Our ref: 25_33878_P

Site Location: Acorn Lodge Cranesgate North
Whaplode St Catherine Spalding PE12 6ST

Summary of Proposal: Change of use of land to domestic & erection of workshop & stores

SITE PLAN 1:500

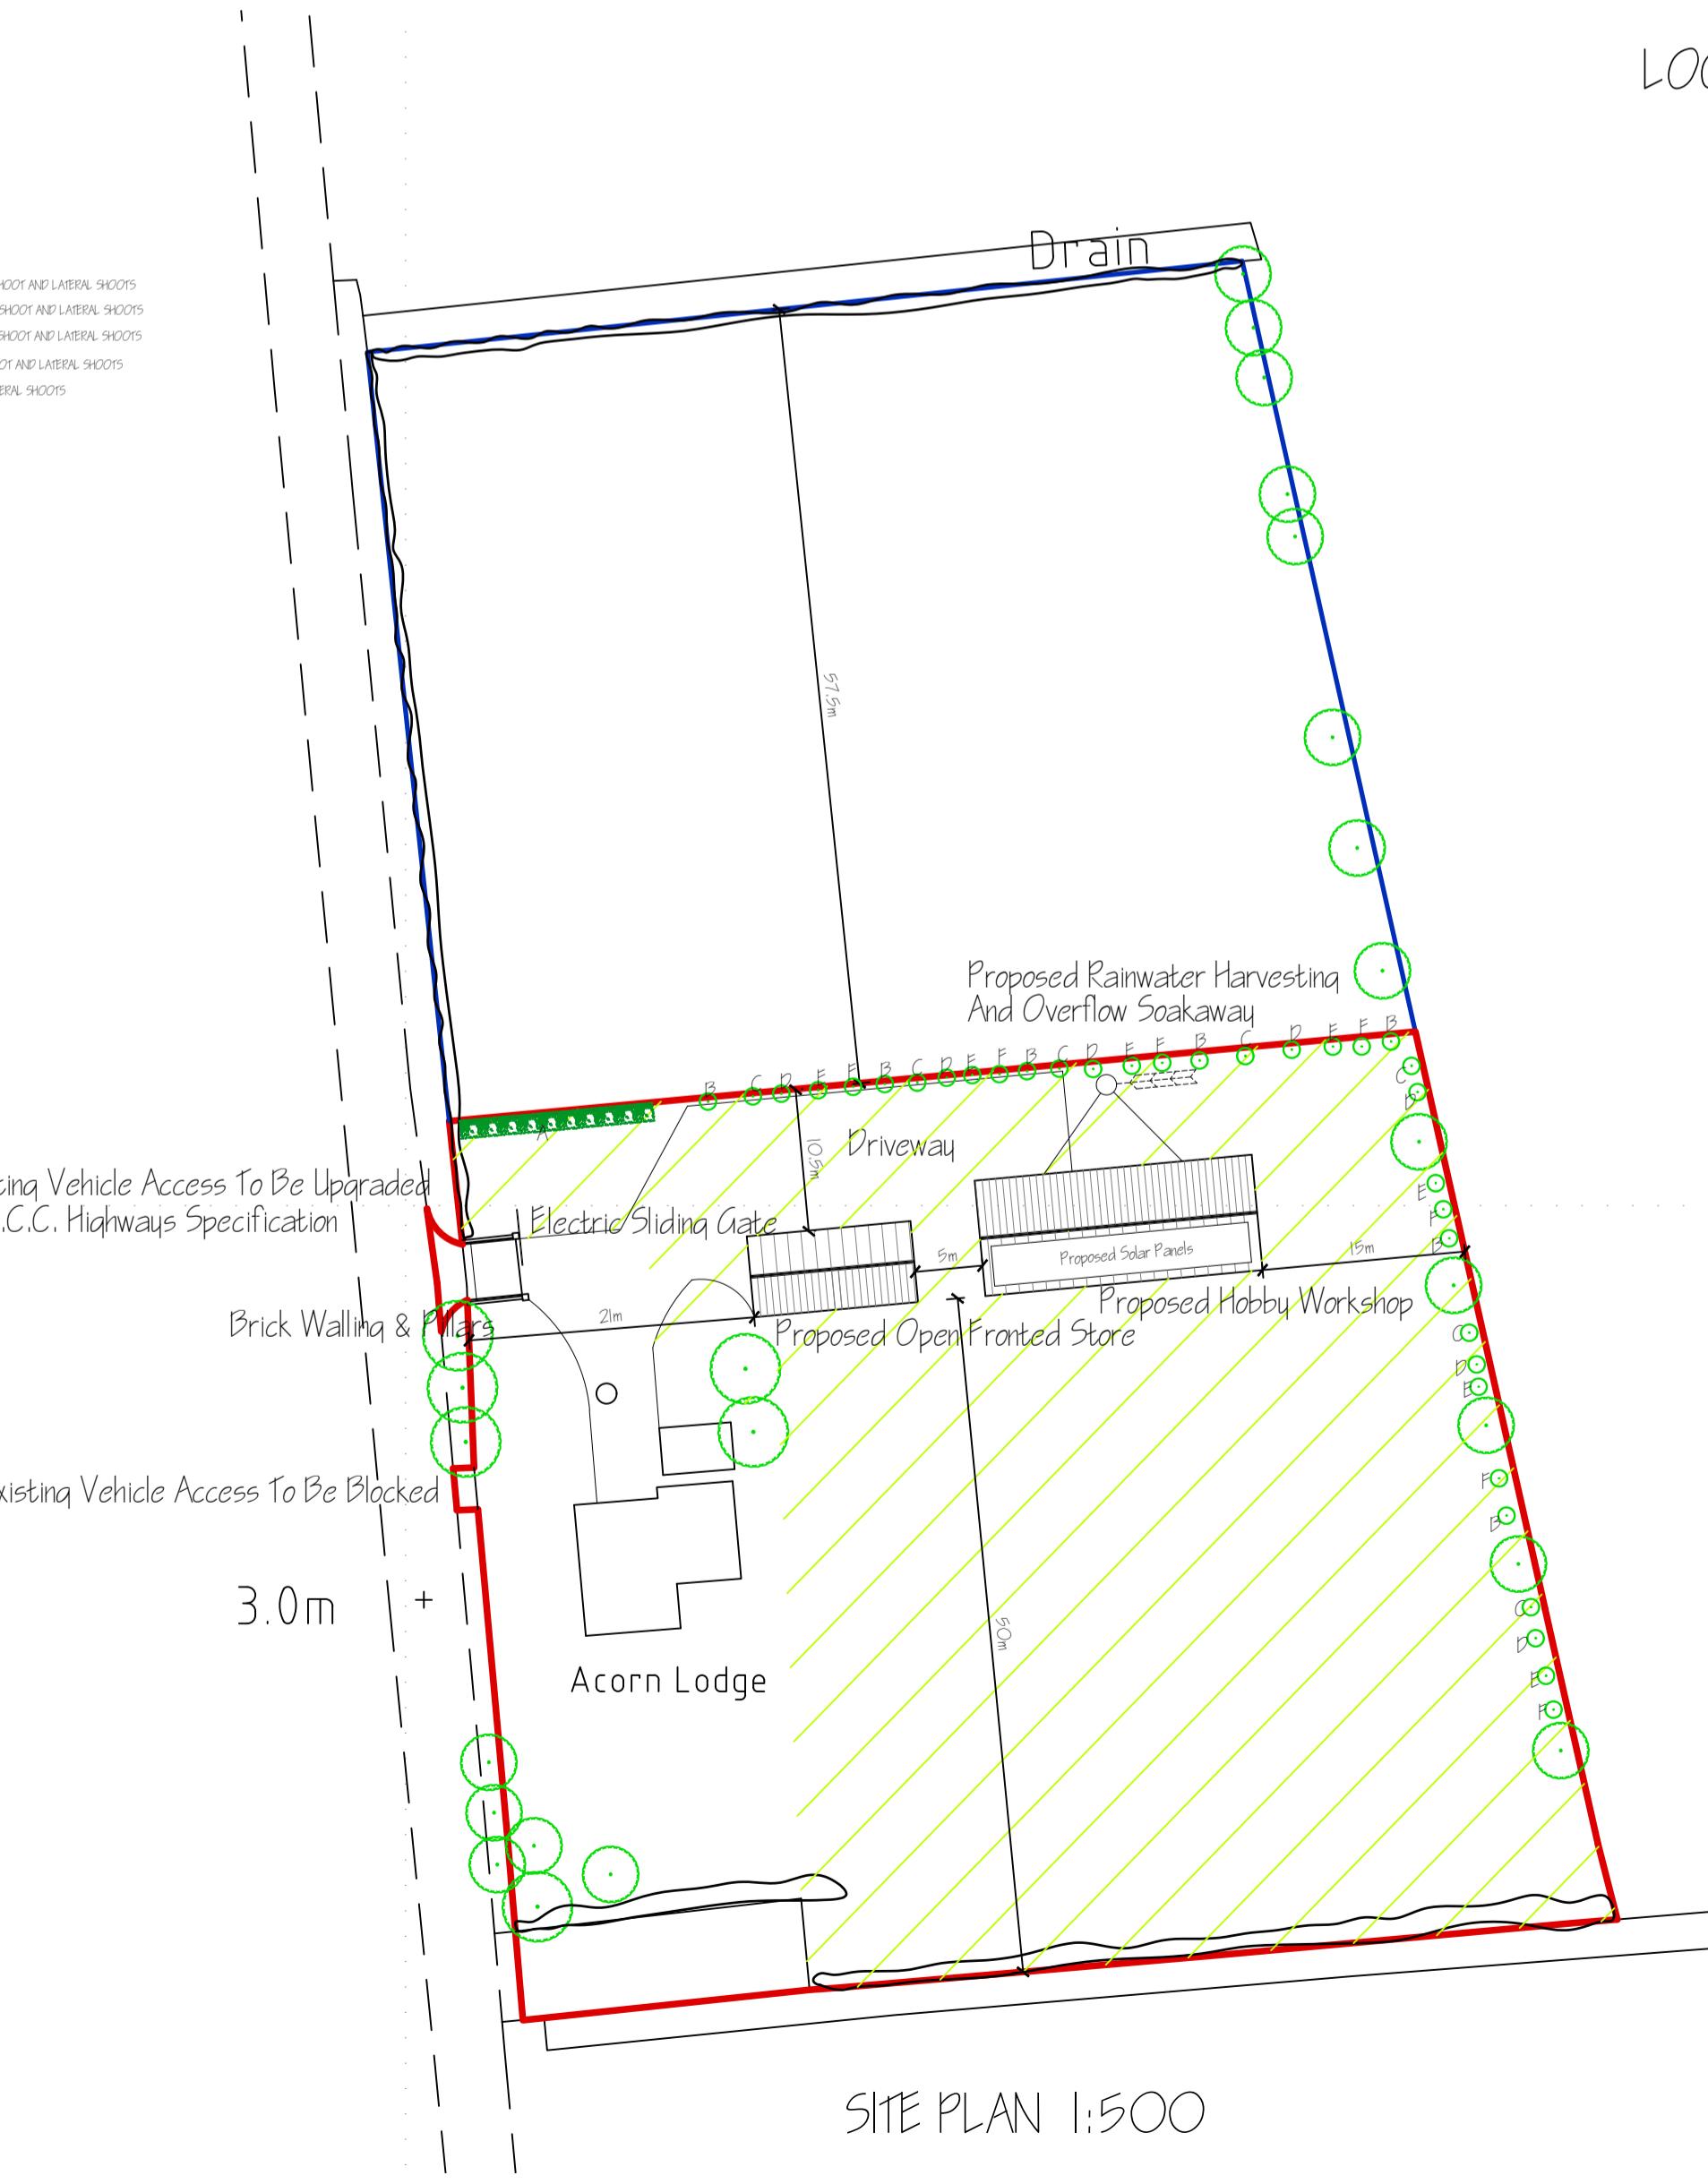
The applicant has indicated that they intend to dispose of surface water via infiltration, however I cannot see that the viability of this proposal has been evidenced. We recommend that ground investigation is carried out to determine infiltration potential, followed by testing in line with BRE Digest 365 if onsite material is considered favourable for infiltration.

If infiltration is not feasible at this site, following the drainage hierarchy we would expect the applicant to propose to discharge surface water to a watercourse. In this case, consent would be required under Byelaw 3. The Board recommend that any discharge is in line with the [National standards for sustainable drainage systems \(SuDS\)](#) published in June 2025. Further to the National Standards for SuDS, the Board's policy is to restrict discharges to 2/l/s/ha or annual average flood flow rate (QBar or QMed), whichever is higher.

I note the presence of a watercourse which is not maintained by the Board (a riparian watercourse) adjacent to the northern and southern site boundaries. Whilst not currently proposed, should the applicant's proposals change to include works to alter the riparian watercourse, or if works are proposed to alter the watercourse at any time in the future, consent would be required under the Land Drainage Act 1991 (and Byelaw 4).
